Consultation Response from KC Highways Development Management		
2026/90271 Pilgrim Foodservice, Forge Lane, Thornhill Lees		
Change of use of existing industrial storage unit to wholesale supermarket, erection of single-storey extension, formation of mezzanine level, installation of canopy over customer entrance, external re-cladding and associated works		
Date Responded: 25/06/26	Responding Officer: M Zenner	Responding Ref: 15-1SW/3

Figure 2: Extract from the Proposed Site Layout.

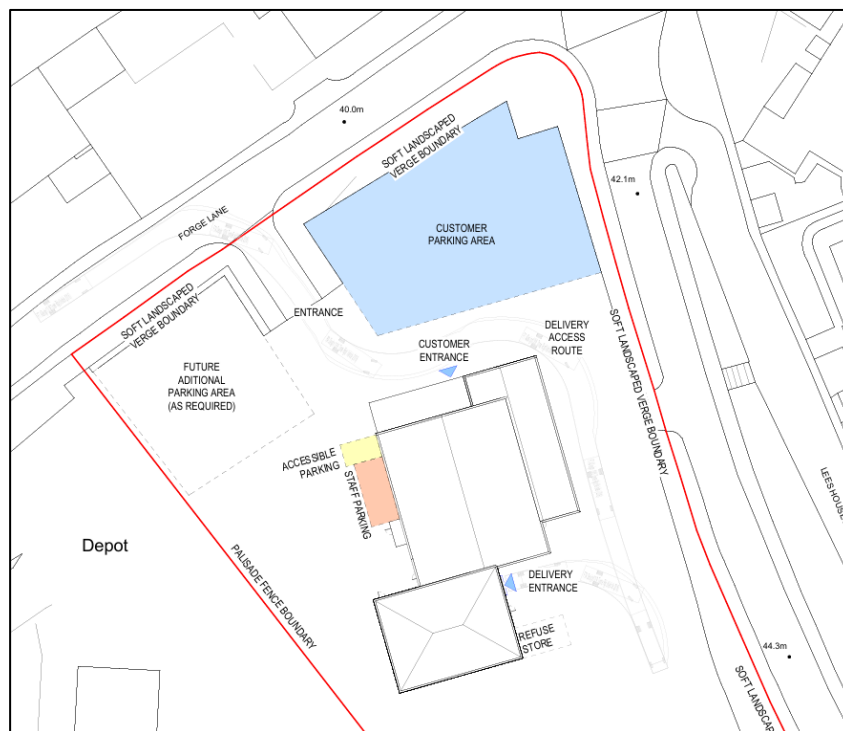
The proposals include 40 no customer parking spaces adjacent to the Forge Lane frontage to the east of the site access. To the west side of the building 1 accessible parking space, 1 EV charging space and 3 staff parking spaces are provided. Furthermore, there is an area adjacent to the Forge Lane frontage to the west of the site access detailed as 'future additional parking area (as required)' but no layout has been provided, just a dashed line outlining the location.

The proposed site plan indicates a delivery entrance at the rear of the building and indicates that the delivery access route travels past the northeast corner of the building and therefore it is anticipated that deliveries will be made via the Forge Lane access. The submitted floorplans indicate that the rear part of the building would be used as a storage area. The proposed building alterations include a mezzanine floor which is detailed as provided a prayer room, a kitchen, an office, toilets and two store rooms.

The proposed access onto Forge Lane is proposed to be retained as existing. Whilst no dimensions have been provided it appears to be a 6.5m wide access route for vehicles with a footway on either side that extends for approximately 12m from the soft landscaped verge boundary into the site before ending abruptly. The existing and proposed plans do not reference the existing boundary wall along the Forge Lane frontage either side of the existing access which should be clarified. The footway on the east side is approximately 4m wide and the footway on the west side of the access is approximately 3m wide.

No information regarding the size of vehicles that will be required to service the site has been provided, and no swept paths have been demonstrated to ensure they can access and egress the site acceptably from a highway safety perspective; which should be addressed. Swept paths of the turns from Forge Lane should be provided to ensure that turning vehicles do not impede opposing traffic movements. In addition to this, there are regularly vehicles parked on-street on Forge Lane in the vicinity of the site access which could have an impact on the operation of the access; which should be considered.

No visibility splays have been provided as part of the submission which should be provided. 2.4m x 43m should be provided in accordance with the requirements set out in Manual for Streets, vertical visibility should be considered alongside horizontal due to the change in levels from within the site down onto Forge Lane and should consider the boundary treatment, including if the existing boundary wall is to be maintained as this may impede the visibility of small children walking along the rear of the footway.

Pedestrian access within the site is proposed via the two 12m length footways located either side of the existing Forge Lane vehicle access. HDM is concerned that the proposed arrangements do not provide a safe accessible arrangement for pedestrians through to the entrance of the site from the site access. Furthermore, there is very little pedestrian infrastructure proposed to access the car parking spaces bearing in mind the delivery access route appears to route between the customer entrance and the customer car parking spaces. No safe and accessible pedestrian route appears to be provided for the accessible parking space, the EV charging space or the staff parking spaces which should be addressed also.

Parking spaces are noted as 2.4m x 4.8m with 6m aisle widths, other than the accessible space which has approximately 1m aisles on two sides and to the rear. HDM require parking spaces to be 5m x 2.5m with 6m aisle widths. These slightly larger spaces are needed for retail uses due to the higher turnover of spaces. Accessible spaces should have a 1.2m aisle to one side and to the rear.

Whilst there is an unnamed store adjacent to the staff parking, it is not clear if this is proposed for staff use and no visitor/customer cycle parking is noted within the site.

Limited details have been provided in relation to servicing or waste management which should be clarified. A delivery entrance is shown to the rear of the building and the north east corner of the building is annotated with 'delivery access route'. A refuse store is outlined at the rear of the building but no details have been provided in relation to the number and size of vehicles that will be required to service the site and no swept paths have been provided to demonstrate how the path of vehicles proposed to access and egress the site as well as passing through the site.
